**Town of Addison
Summary of Engineering Revision Comments**

Development: Galaxy FBO

Town Project #:19-09D

Town of Addison Engineering Review Conditional Civil Approval

C10.06

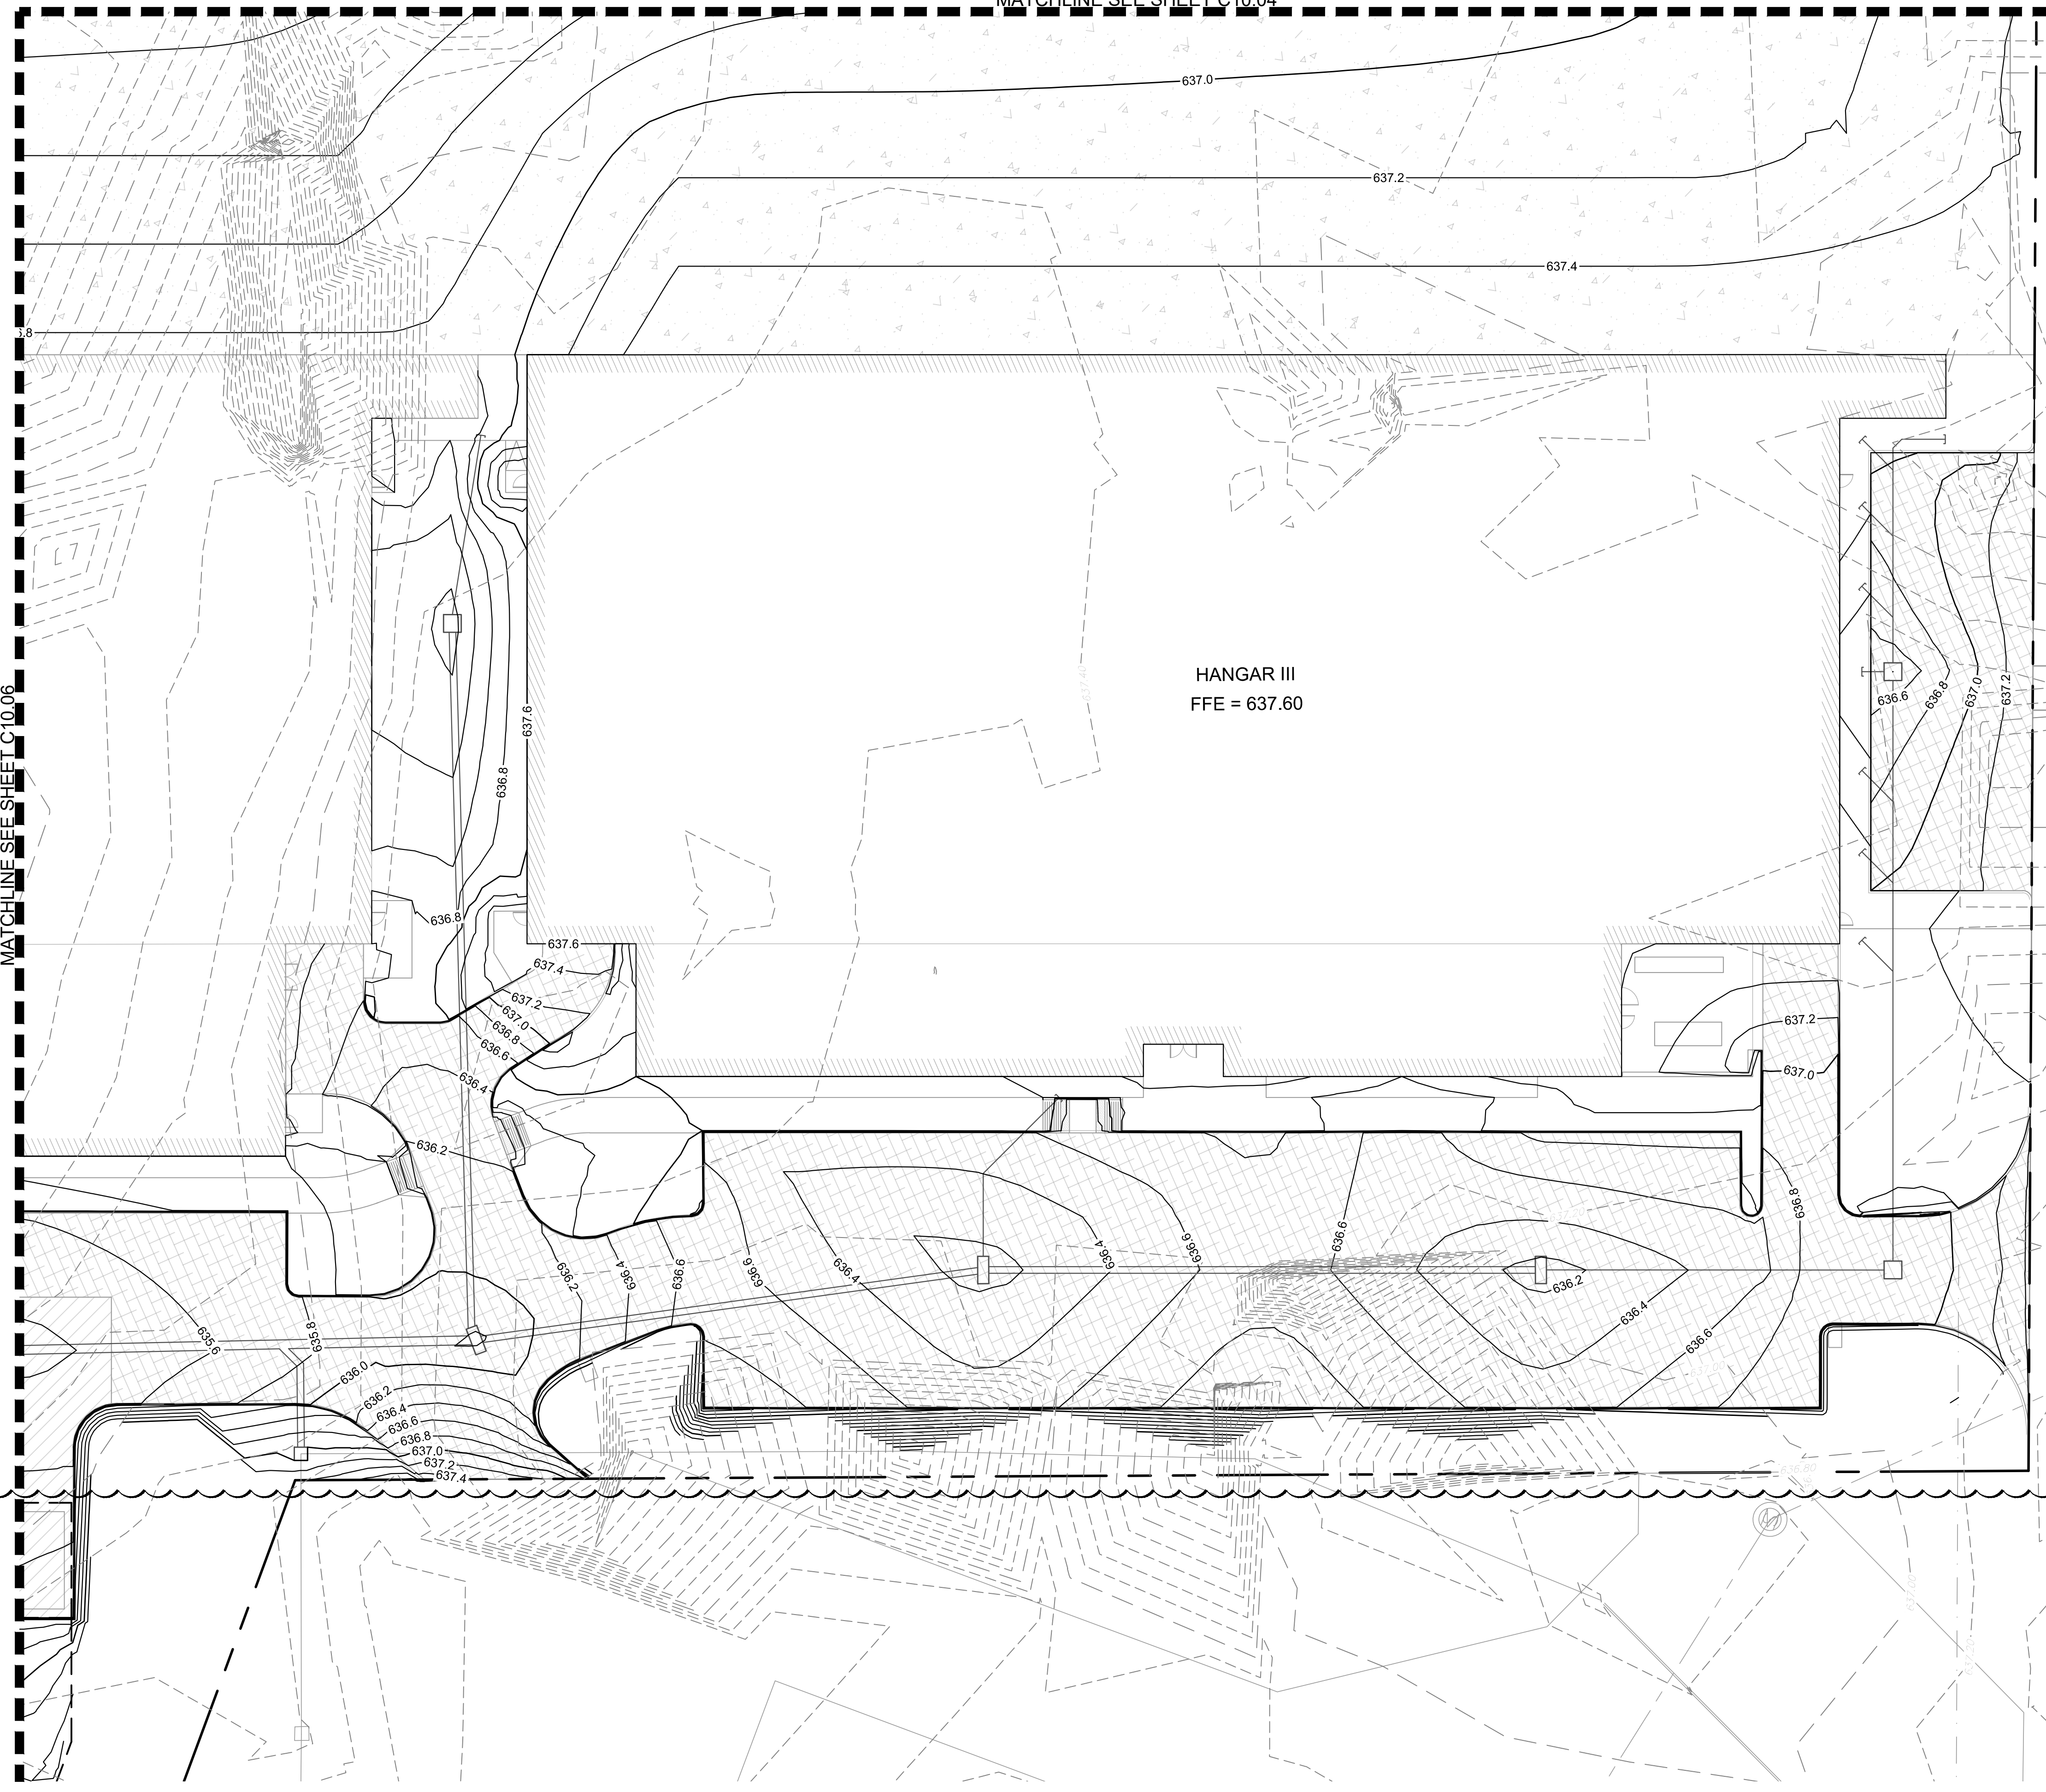
ASI-C006	10/30/2020	C10.04	Updated grading per field conditions verified by a construction progress topographic survey.	
ASI-C006	10/30/2020	C10.05	Updated grading per field conditions verified by a construction progress topographic survey.	
ASI-C006	10/30/2020	C10.06	Updated grading per field conditions verified by a construction progress topographic survey.	
ASI-C006	10/30/2020	C10.07	Updated grading per field conditions verified by a construction progress topographic survey.	
ASI-C006	10/30/2020	C10.08	Updated grading per field conditions verified by a construction progress topographic survey.	
ASI-C006	10/30/2020	C12.02	Updated rim and top of grate elevations on storm structures per field conditions verified by a construction progress topographic survey.	
ASI-C006	10/30/2020	C12.03	Updated rim and top of grate elevations on storm structures per field conditions verified by a construction progress topographic survey.
